## MEMORANDUM

**TO:** Caitlin Cameron, Planner  
**FROM:** David Senus, P.E.  
**DATE:** July 2, 2014  
**RE:** 185 Fore Street, Preliminary Level III Site Plan Application

Woodard & Curran has reviewed the Response to Review Comments letter for the Preliminary Level III Site Plan Application for the proposed mixed-use building located at 185 Fore Street in Portland, Maine. The project consists of constructing a four story building with retail uses on the ground floor and six residential units on the upper floors.

- Response to Review Comments Letter for the Level III Preliminary Site Plan Application and attachments, dated June 13, 2014, prepared by FST on behalf of Bateman Partners, LLC.
- Engineering Plans, Sheets C-1.0, C-1.1, C-2.0, C-2.1, C-3.0, C-4.0, C-5.0, C-6.0, C-6.1, C-6.2, REV. dated June 12, 2014, prepared by FST on behalf of Bateman Partners, LLC.
- E-1.01 dated June 13, 2014 prepared by Bennett Engineering.

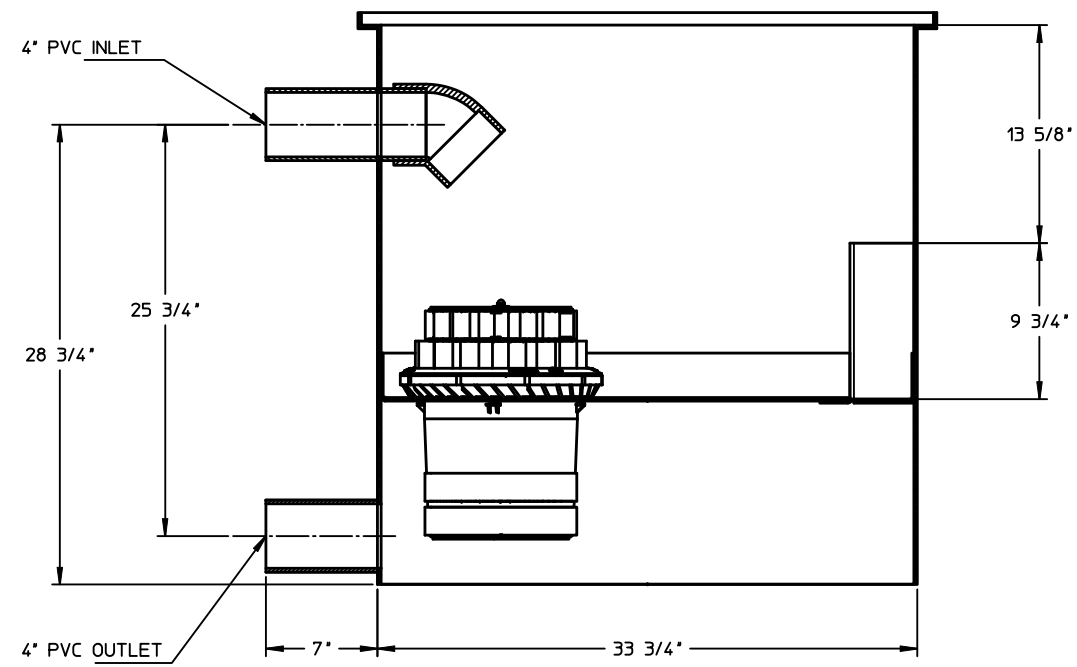
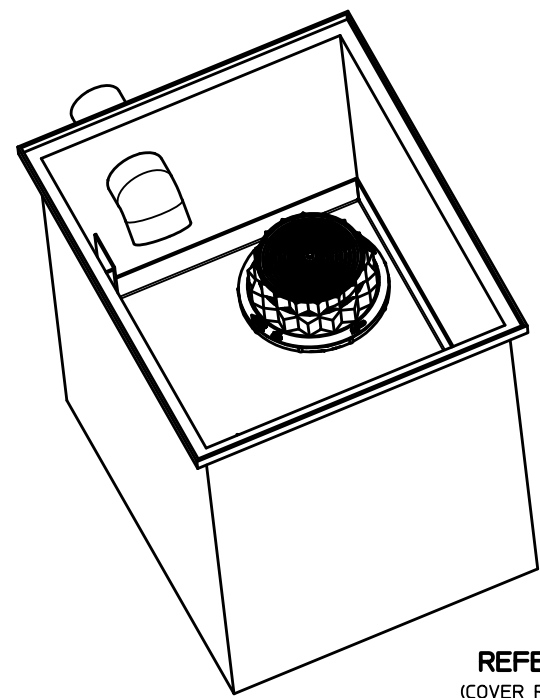
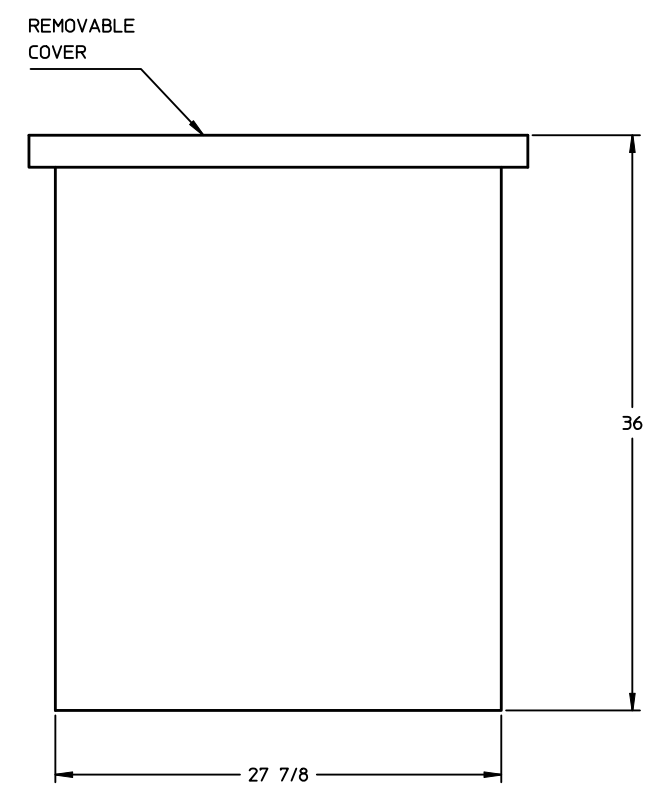
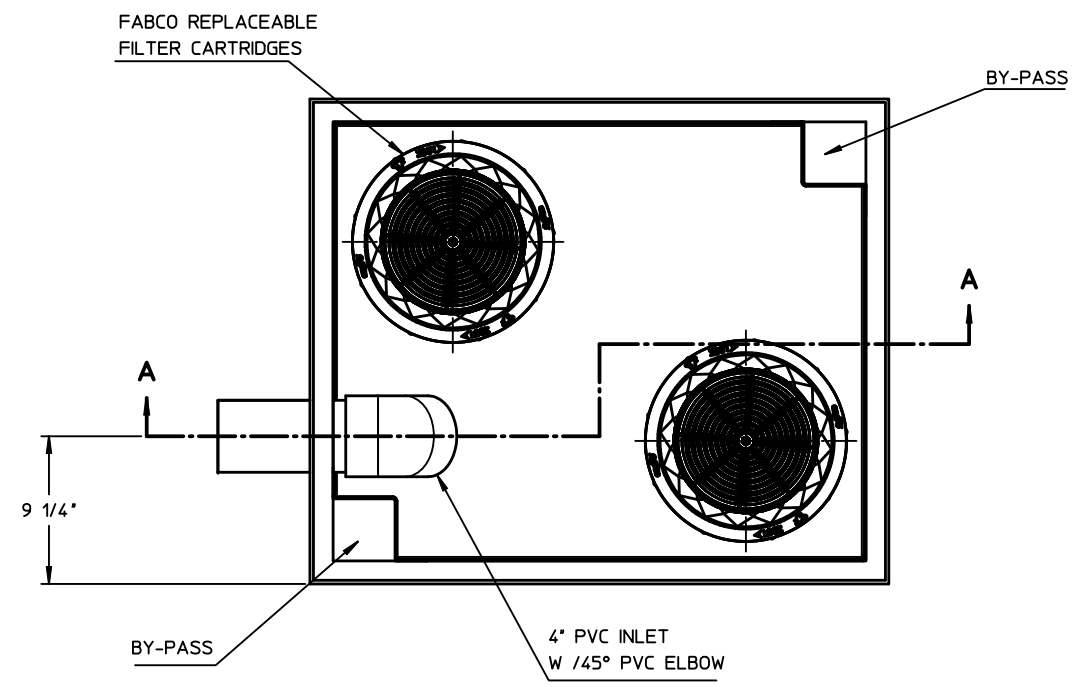
- b) General Standard: The Applicant has provided pollutant removal data for the cartridge filter treatment unit for managing building roof runoff (a Fabco Industries cartridge system). The proposed unit provides an acceptable means of achieving water quality treatment for the site.
